M20 Junction 10a

(TR010006):

Correspondence received by the Department for
Transport in the Decision period

Project Title		M20 JUNCTION 10A			
Drawing Title		RIGHTS OF WAY AND ACCESS PLANS			
Drawing Status		DCO SUBMISSION (TR010006)			
Scale		1:1250			
Original Size	Date	Designed	Drawn	Checked	Authorised
A1	JULY 16	RD	RD	FT	HNK
Drawing Number		HA514442-MMGLV-GEN-SMW-DE-Z-2403			
Revision		B

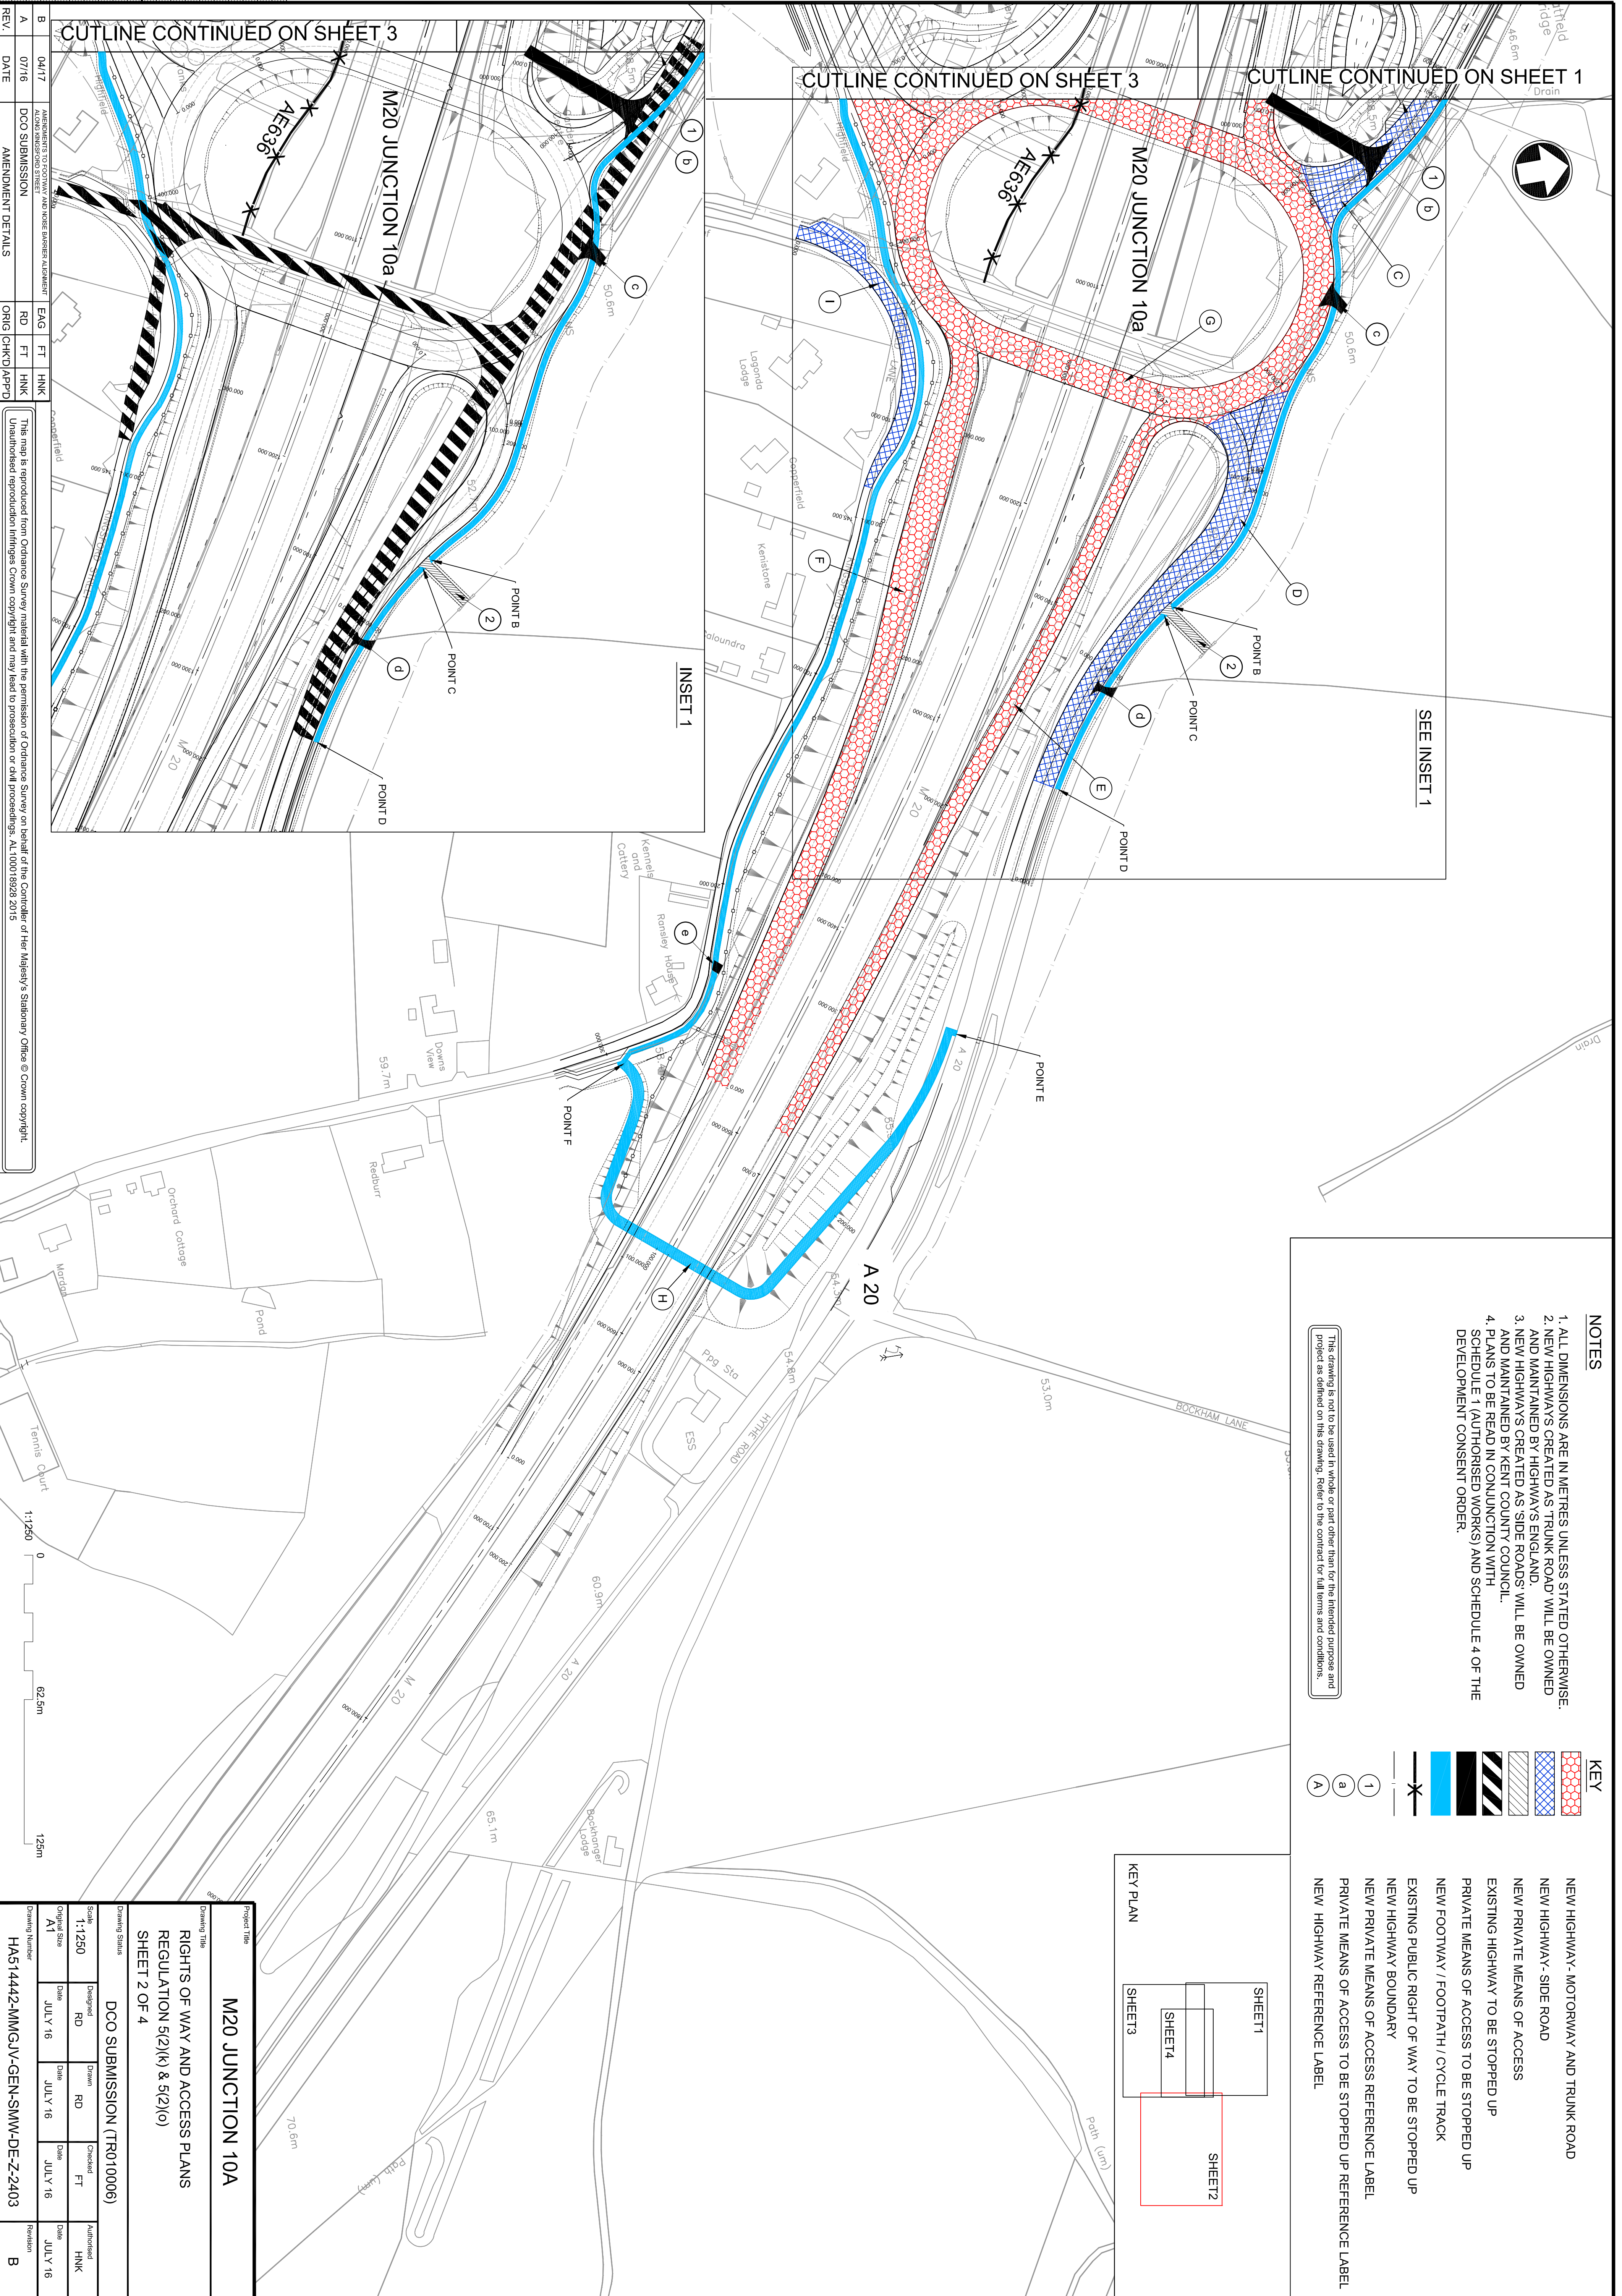
Drawing number HA514442-MMGJV-GEN- SMW-DE-Z-2403

Sheet 2 of 4 in the Rights of Way and Access Plans found in the submission drawings.

The video is taken walking on the motorway side of the A20 from where you would exit the new bridge.

To the north of the motorway you will see there is no link between point D&E. Where the people exit the bridge there is no pavement, there will be no option but to cross the A20. This is on a blind bend. As you can see a reduction in speed at this point will not make the A20 any safer to cross.

At present crossing points further west on the A20 have a safe area mid crossing, this will not be the case here. There will be no pedestrian crossing points on J10a. (There are on the present J10)

People from Mersham and other villages are being encouraged to use the new bridge. It is a designated bridleway so horse riders are expected to use the bridge as their link from Bockham Lane across the M20 motorway to the rest of the network.

Despite requests to extend the bridge over the A20 or to provide a signalised pedestrian crossing HE's reply was 'they would wait and see if anyone used the bridge!' The planning inspector asked if that was really HE's solution, only make it safe if it was used. Thus it seems HE expect it to be either unused or unsafe.

It seems a complete waste of money to build a pedestrian bridge with an inherent safety flaw, that will prevent it being usable.

Can you as part of your decision consider making this crossing safe?
